Your Ref SSD-9579147

COUNCIL SUBMISSION

NOTICE OF EXHIBITION OF ENVIRONMENTAL IMPACT STATEMENT FOR THE REDEVELOPMENT OF PENDLE HILL HIGH SCHOOL (66 BINALONG ROAD, TOONGABBIE)

Figure 5 Option 4
Source: Architectus

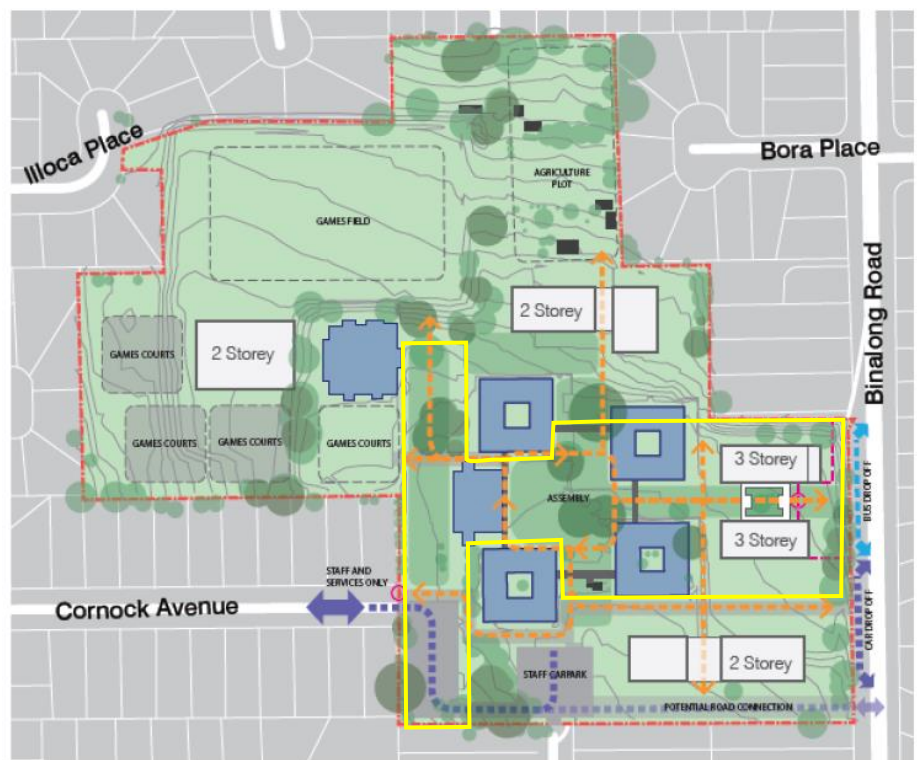
The long-term master plan (Architectus) for the school included in the Design Report indicates a street along the southern boundary between Cornock Avenue and Binalong Road also linking to Knox Road. The submitted documentation does not include this as a feature in the current scope of works. It is the opinion of Urban Design that if this is not developed now it is unlikely to be developed later.

Ideally this link should be a formed laneway 9m wide (6m vehicular + 3m pedestrian & cycle shareway) that can accommodate service and emergency vehicles and has visual surveillance from neighbouring properties. This laneway may be closed to regular traffic with bollards but should otherwise read as a public street.

- A. A direct, signposted, well-lit and publicly accessible pedestrian through link (min 3m wide) in the non-secure/non-fenced area of the school grounds connecting Binalong Road, Knox Road and Cornock Avenue is recommended (aligned with Architectus' Master Plan). This link should be designated as a Right of Way (ROW) in the land title.

Figure 16 Current play space, games courts and sports field at the school
Source: Fulton Trotter Architects.

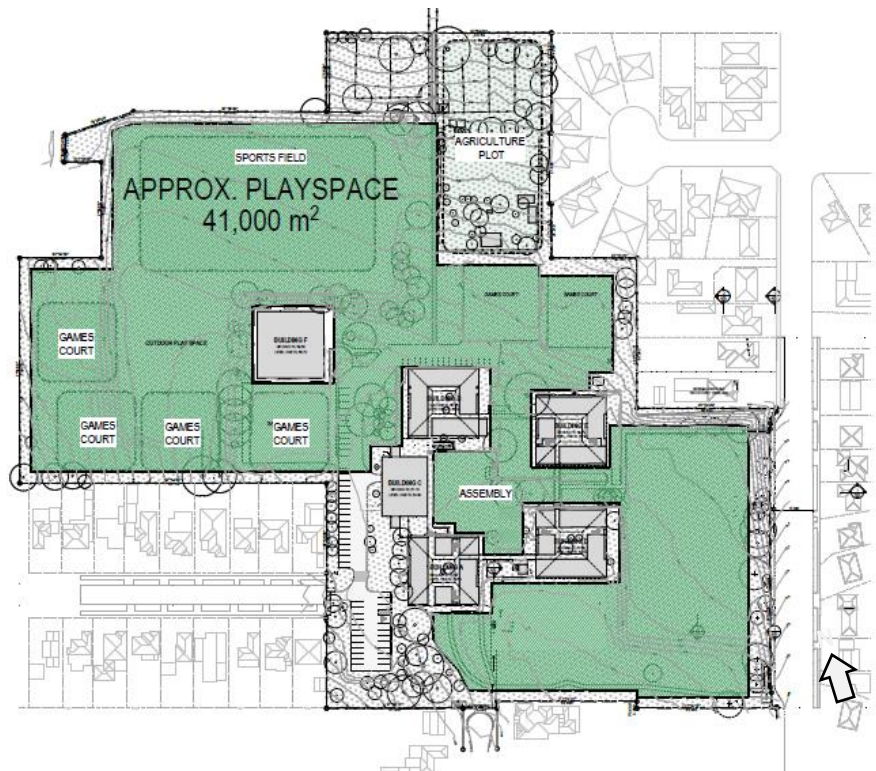
2. Providing adequate shading over hardcourts to ensure these spaces are used during hot days.

As identified in the previous recommendation, increasing the thermal comfort of these spaces can assist in future-proofing recreational facilities at Pendle Hill High School.

4. Embellishment of existing hardcourts

To ensure they have desired recreation spaces that perform at a suitable standard.

Figure 20 Northern Elevation

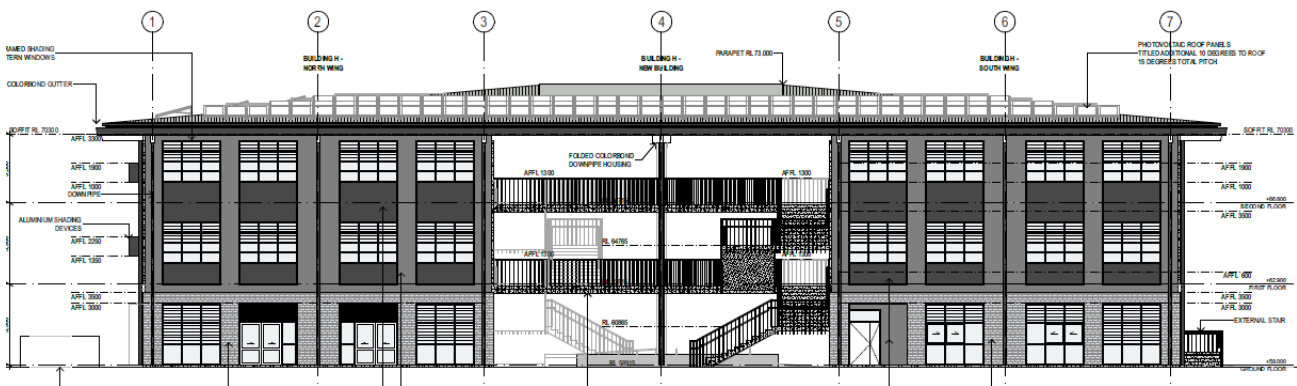
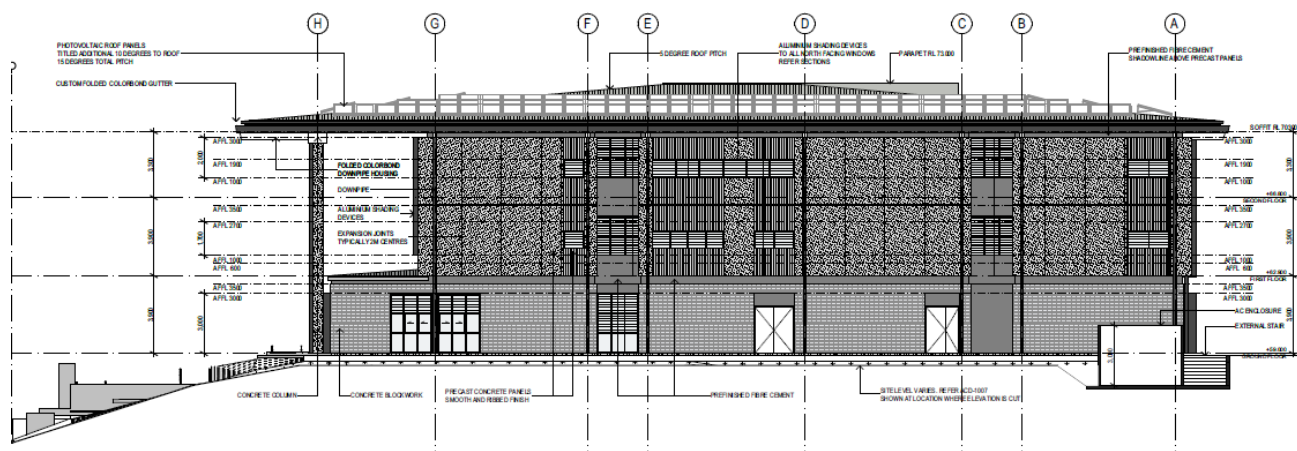
The site is elevated along Binalong Road - this combined with the scale of the building and the cantilevered roof appears bulky along the northern boundary with the existing context of predominately one and two storey residential dwellings. Should the scale of

building not be altered, large canopy tree planting with understory screen planting along this edge is recommended to provide some screening and visual privacy to the adjoining residents.

- B. Large canopy tree and understorey screen planting should be conditioned as part of the development to provide visual privacy and screening to properties to the north of the proposed school building (82-88 Binalong Road).
